**CITY OF PORTLAND, MAINE
DEVELOPMENT REVIEW APPLICATION
PLANNING DEPARTMENT PROCESSING FORM
ADDENDUM**

2001-0058
Application I. D. Number
04/09/2001
Application Date
Wyoming Ave Lot #26
Project Name/Description
36 - 36 Wyoming Ave, Portland, Maine
Address of Proposed Site
400 A020001
Assessor's Reference: Chart-Block-Lot

TO: Inspections
FROM: Jay Reynolds, Development Review Coordinator 
DATE: September 12, 2001
RE: C. of O. for # 36 Wyoming Avenue;
lead cbl (400A020001); Id# (2001-0058)

4/6/01
 CONCEPTUAL GRADING PLANS LOT 26
 (36 Wyoming Ave) WYOMING
 PLOT PLAN PREPARED BY GREG MCCORMACK
 BASED ON GRADING PLAN PREPARED BY
 PINKHAM + GREER ENGINEERS.

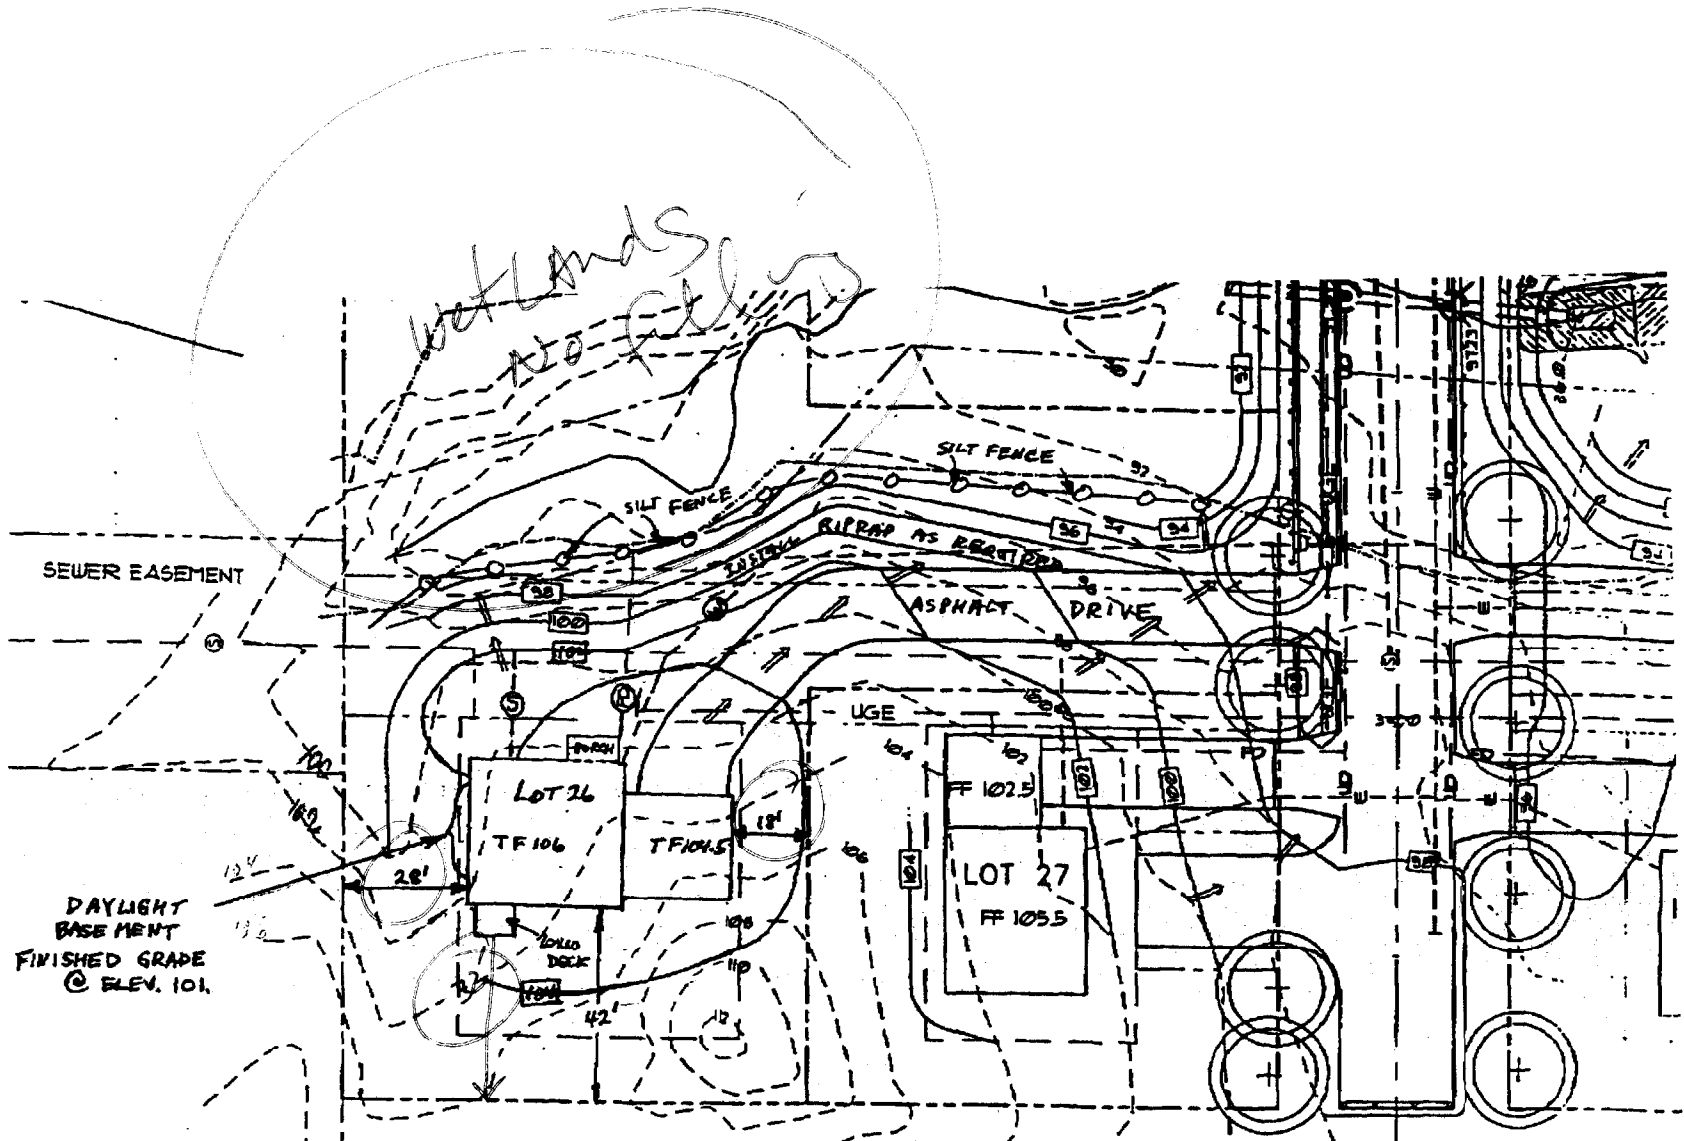
- 1 Prior to Blasting, or issuance of a blasting permit, applicant shall submit to the city's planning dept. The necessary pre-blast information.
- 2 Applicant is to be aware that there is to be "No filling of any area designated as a drainage easement" (note 23 of the recorded subdivision plat). Final grading along the driveway shall conform to this condition.
- 3 All sideslopes that exceed 3 to 1 (33%) shall be rip-rap.
- 4 Applicant will maintain silt fence throughout construction to ensure that the NEARBY WETLANDS are protected at all times.

- 1 This permit is being approved on the basis of plans submitted. Any deviations shall require a separate approval before starting that work.
- 2 Separate permits shall be required for future decks, sheds, pools, and/or garage.
- 3 Street name signs and stop signs are to be erected per the City's requirements by the developer PRIOR to the issuance of the first certificate of occupancy.
- 4 Wetlands have been delineated on this property in the area directly opposite from the building area. This area shall not be filled in without written permission from the planning division.
- 5 The maximum structure height is 35 feet. Your height shown at the lowest portion with the daylight basement has been scaled to be 30 feet. Please be carefull when back filling in order to maintain an allowable height limit.

- 6 The site contractor shall establish finish grades at the foundation, bulkhead and basement windows to be in conformance with the first floor elevation (FFE) and sill elevation (SE) set by the building contractor to provide for positive drainage away from entire footprint of building.
